23 August 2021

**DUNGOG ROAD (MR101) SSD-6612 MARTINS CREEK QUARRY EXTENSION PROJECT,
ADVICE ON AMENDMENT REPORT AND RESPONSE TO SUBMISSIONS, STATION
STREET, MARTINS CREEK**

MARTINS CREEK QUARRY
GRESFORD AND DUNGOG ROAD INTERSECTION WORKS

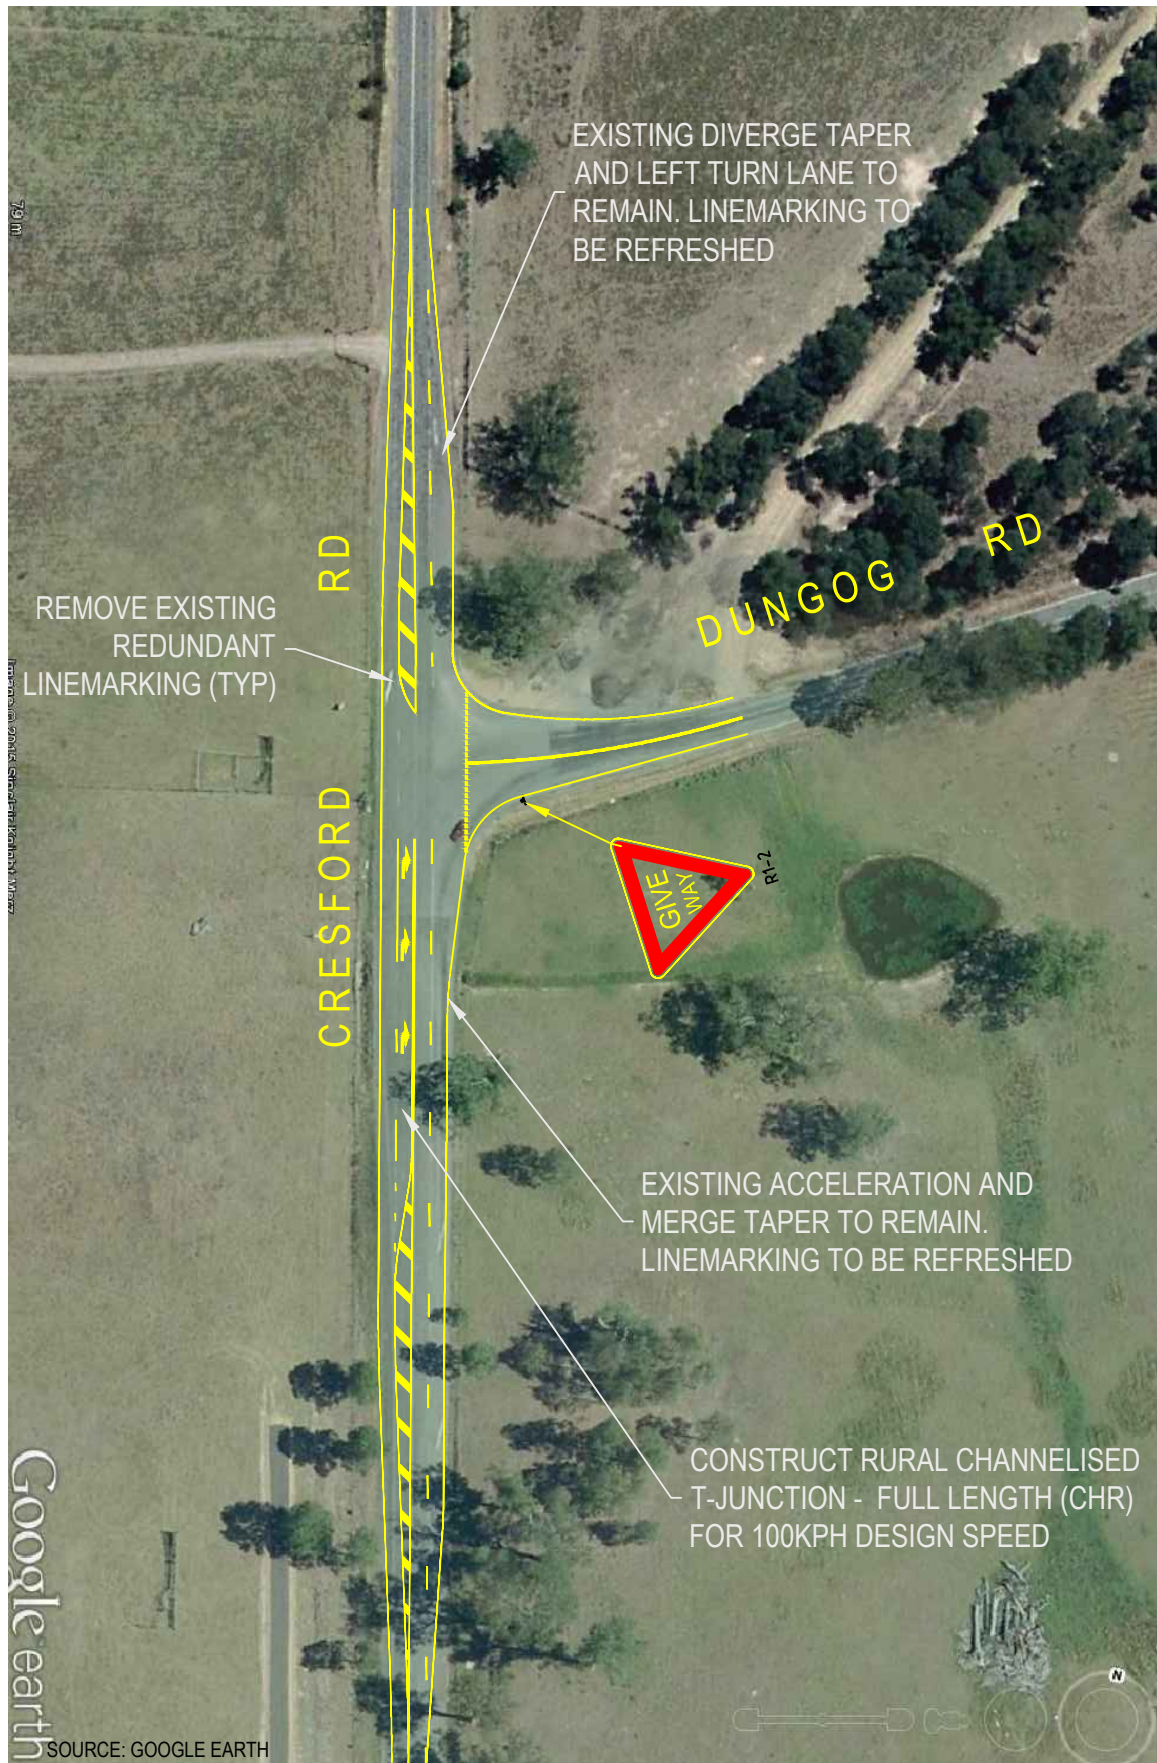
Previous comments provided by TfNSW regarding the intersection of Gresford Road and Dungog Road are generally addressed by Daracon in the RtS. As both Gresford and Dungog Roads are local roads it is recommended Daracon design and construct the intersection in accordance with the relevant standards, to Council's satisfaction, before the commencement of any operational stages of the project.
